Application Ref:	3/2021/0416	 Ribble Valley Borough Council www.ribblevalley.gov.uk
Date Inspected:	22/06/2021	
Officer:	AB	
DELEGATED ITEM FILE REPORT:		APPROVED

Development Description:	Proposed alterations to garage to increase roof height and form office space.
Site Address/Location:	Bashalls Farm, Hothersall Lane, Hothersall PR3 2XB

PROPOSED FLOOR PLANS

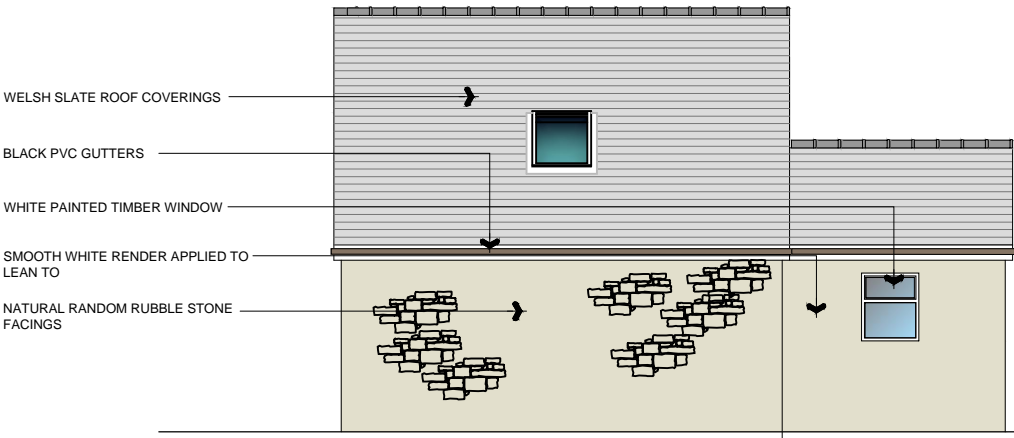
The existing relationship between garage and dwelling would not be fundamentally changed as a result of the proposals. The garage building would remain clearly as an ancillary outbuilding, with its overall height remaining considerably below the height of the main farmhouse.

The provision of rooflights would break what is currently an unadorned slate roof however, subject to the use of conservation style flush fitting roof lights, these would not result in any undue visual harm taking into account that the garage building is not one of the original farmstead buildings and likely a later domestic addition.

PROPOSED FLOOR PLANS

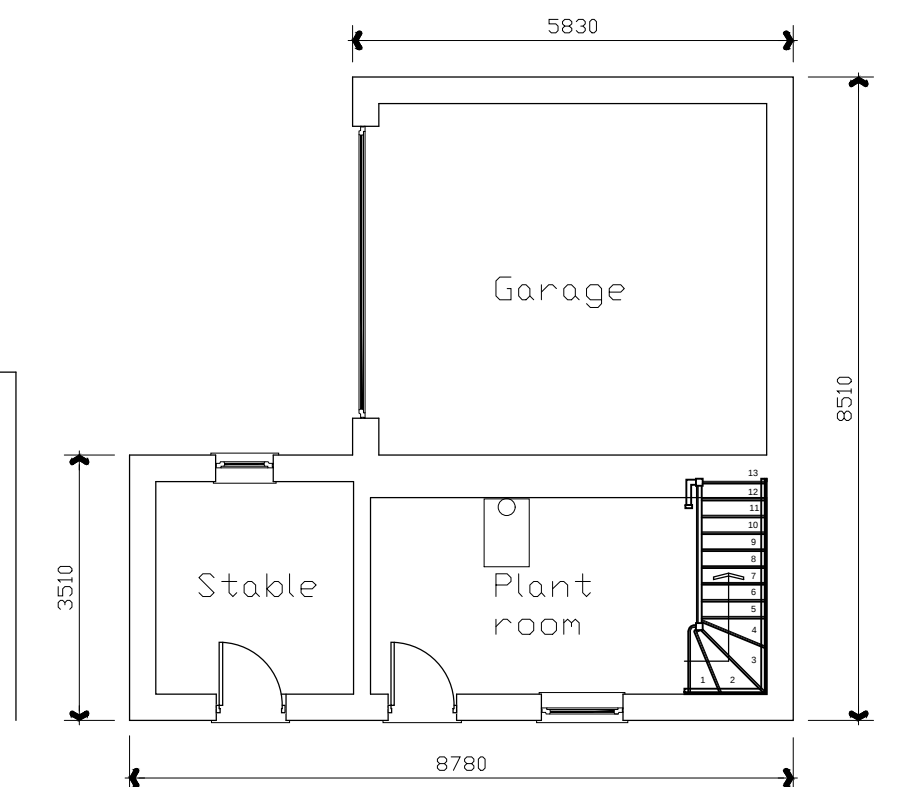
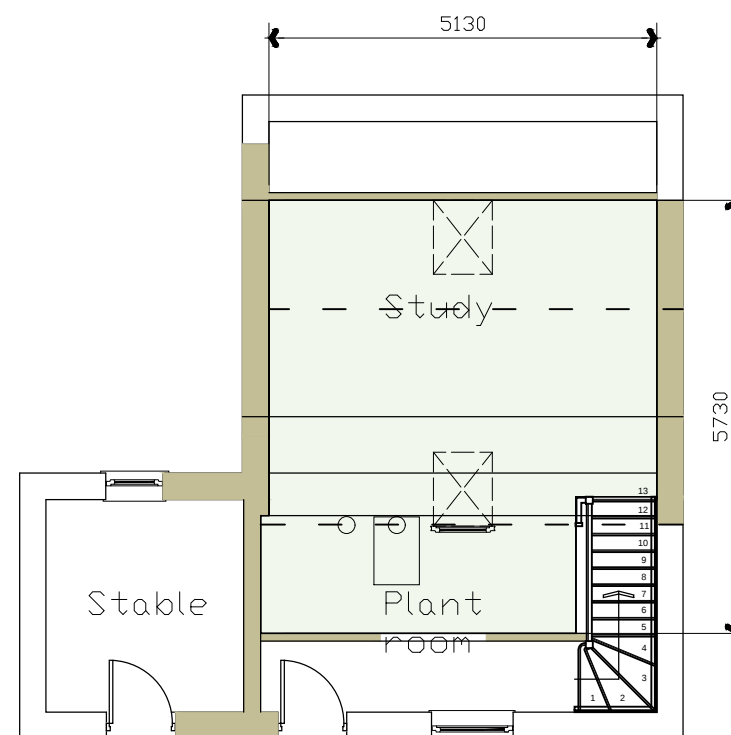
This application relates only to the existing detached garage which is located adjacent to Hothersall Lane. The proposal seeks to increase the roof height by approximately 0.5 metres to form office space above the garage and the introduction of rooflights to serve the first-floor space. The office would be accessed via a new internal staircase.
